DRB CASE ACTION LOG (PREL & FINAL)

DRB Application No.: 05DRB-00816 (P&F)

Project # 1002758

Project Name: CASA GRANDE ESTATES UN 1

PLAT OF  
**LOTS 40-A and 40-B, BLOCK 6**  
**UNIT 1**  
**CASA GRANDE ESTATES**  
 WITHIN  
 SECTION 2, TOWNSHIP 10 NORTH, RANGE 4 EAST, N.M.P.M.  
 CITY OF ALBUQUERQUE  
 BERNALILLO COUNTY, NEW MEXICO  
 MARCH, 2005

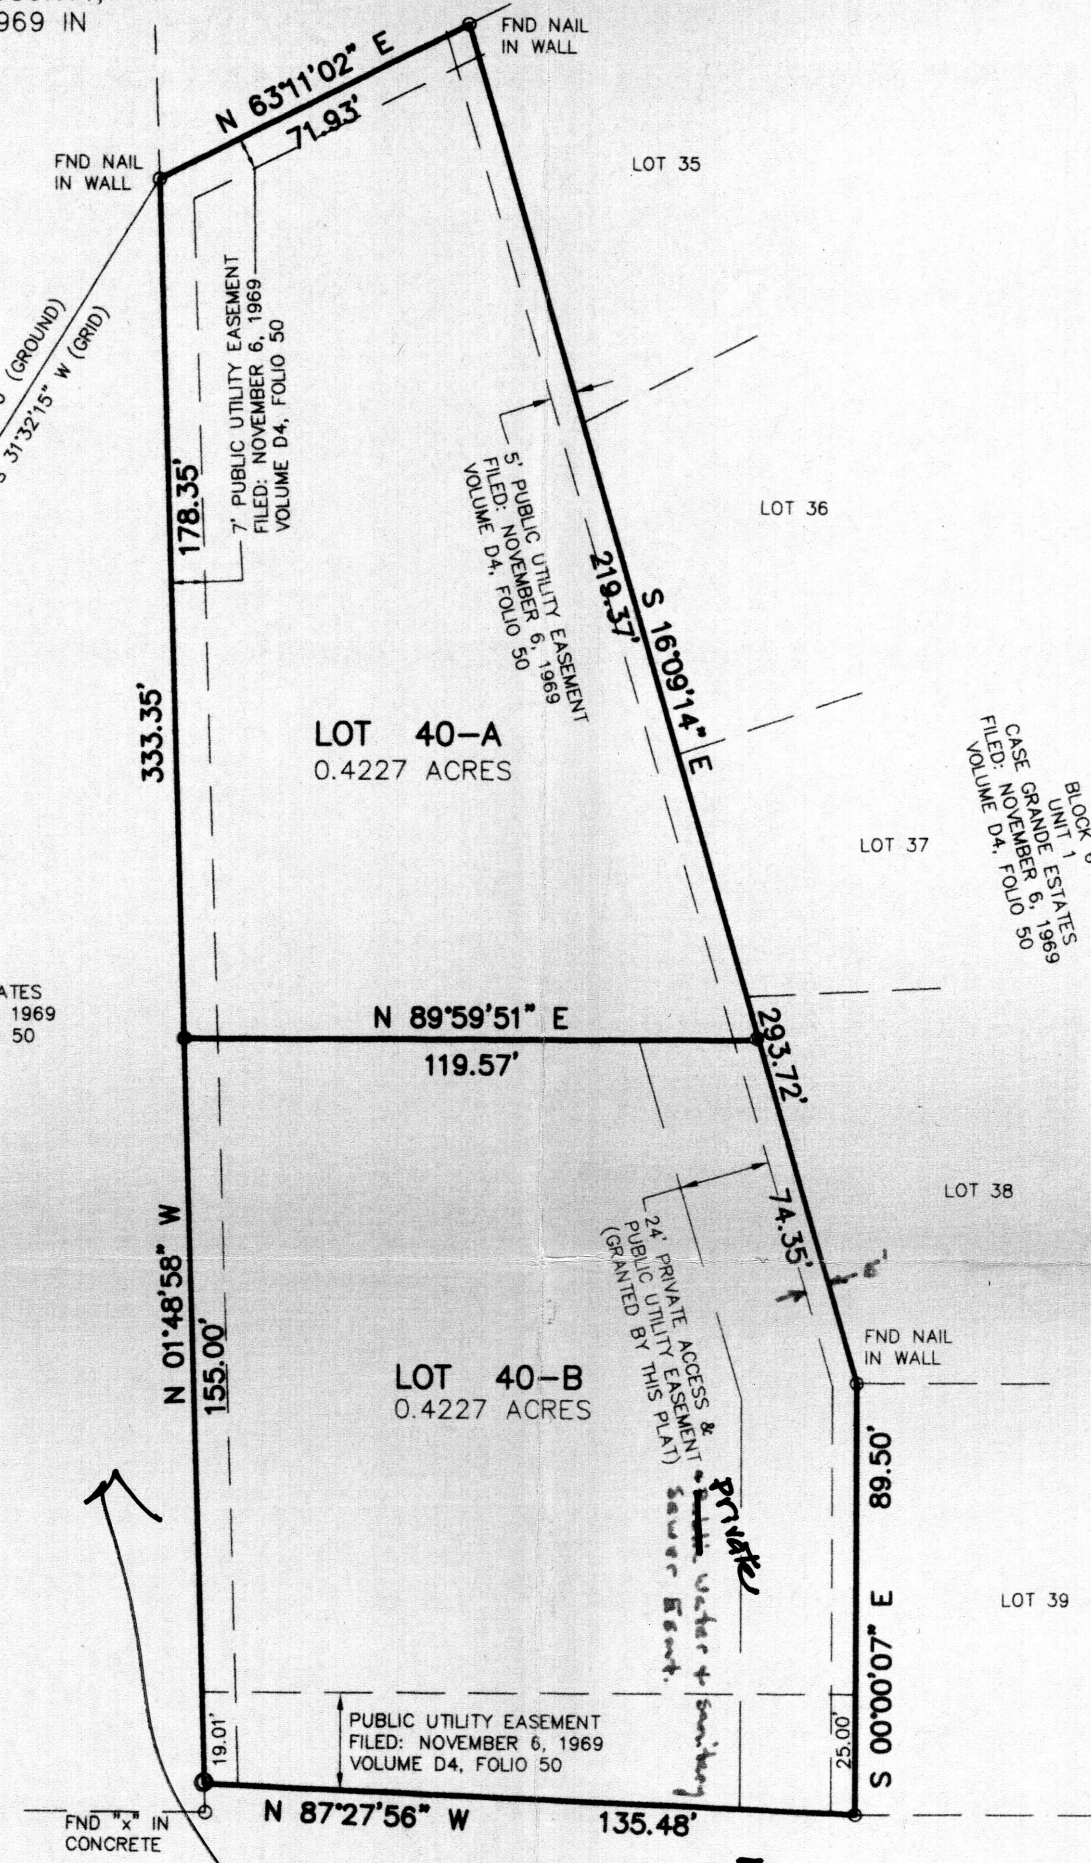
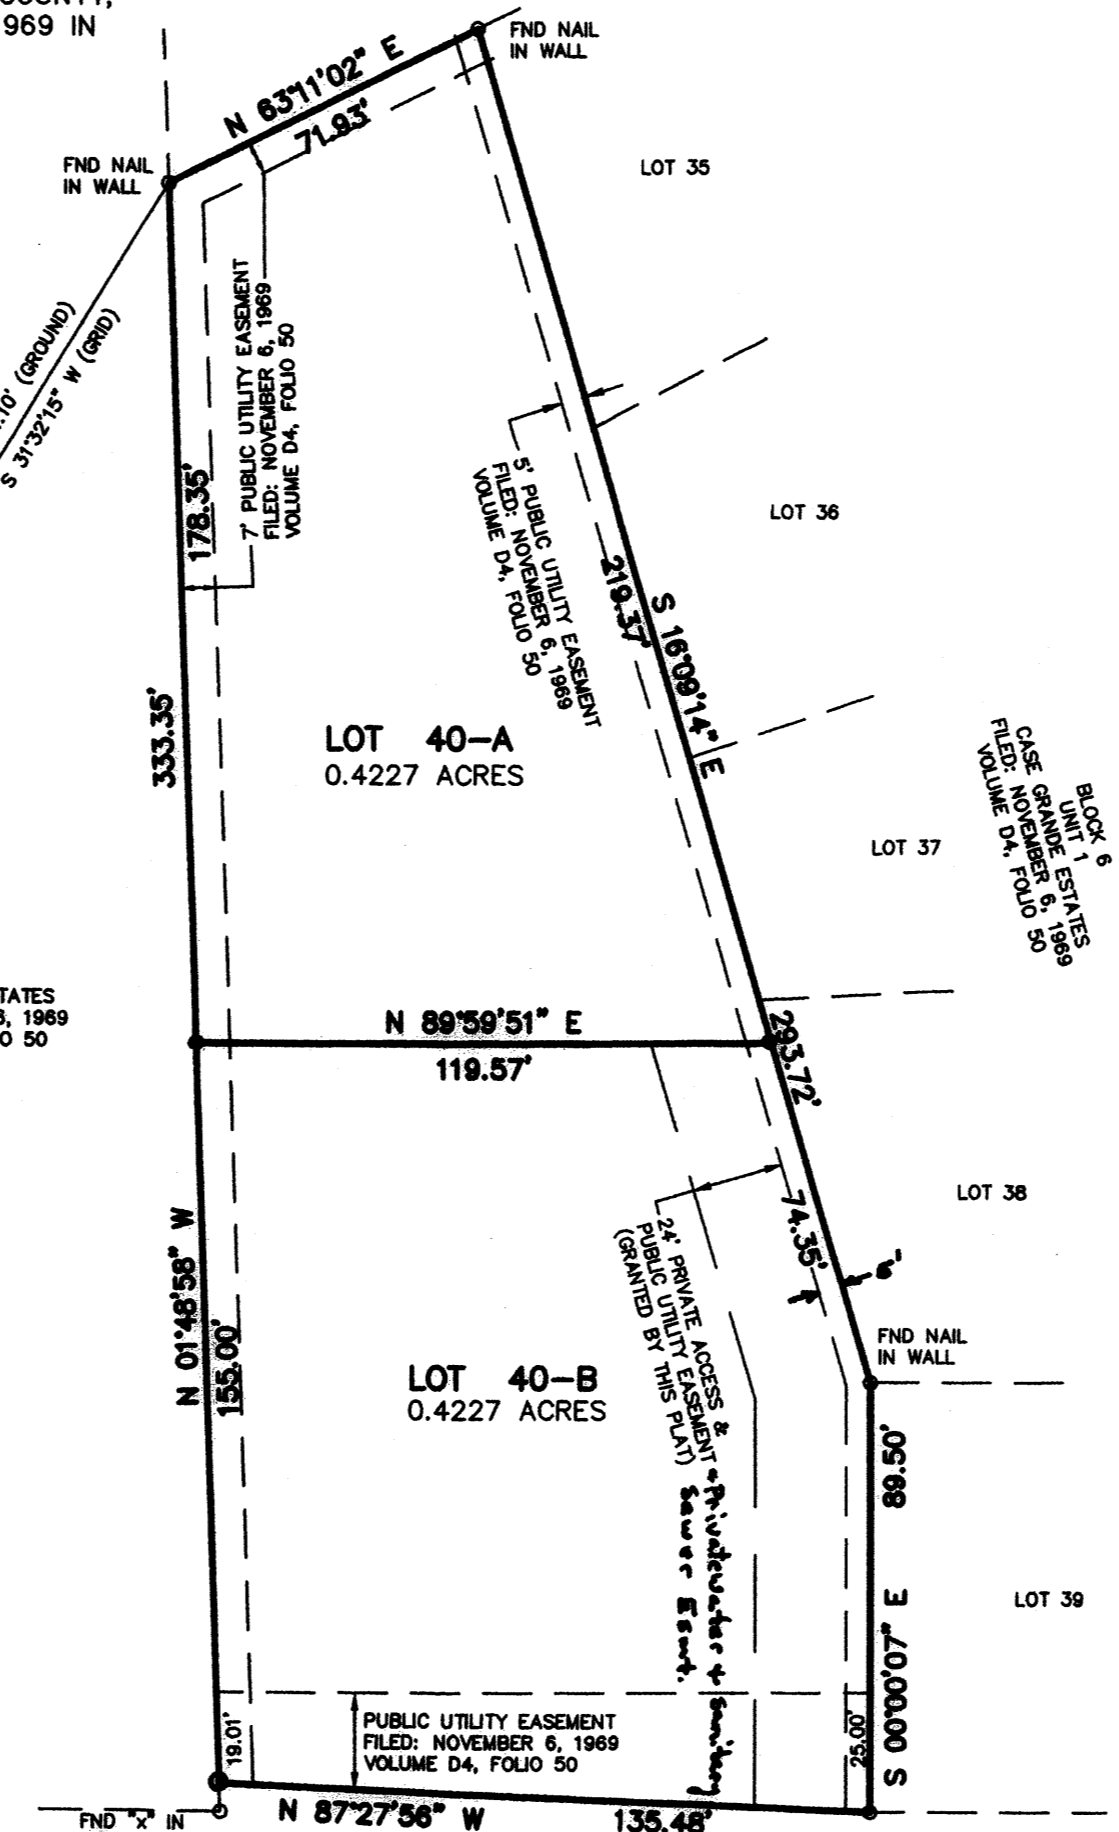
TRANSPORTATION: *dl* - MAINT? BENEFIT. NOTE FOR UMBRELLA ✓
 - DISTANCE FROM FACE OF CURB TO PROT. LINE ✓
 - WIDTH & LOCATION OF SWL ✓
 ok 8-19-05

UTILITIES: Show adjacent off-site easement along West
 P/L for existing water line. 24' wide access easement
 must be labeled "private", not "public" for water/sewer
 services. Need Beneficiary & Maintenance note.
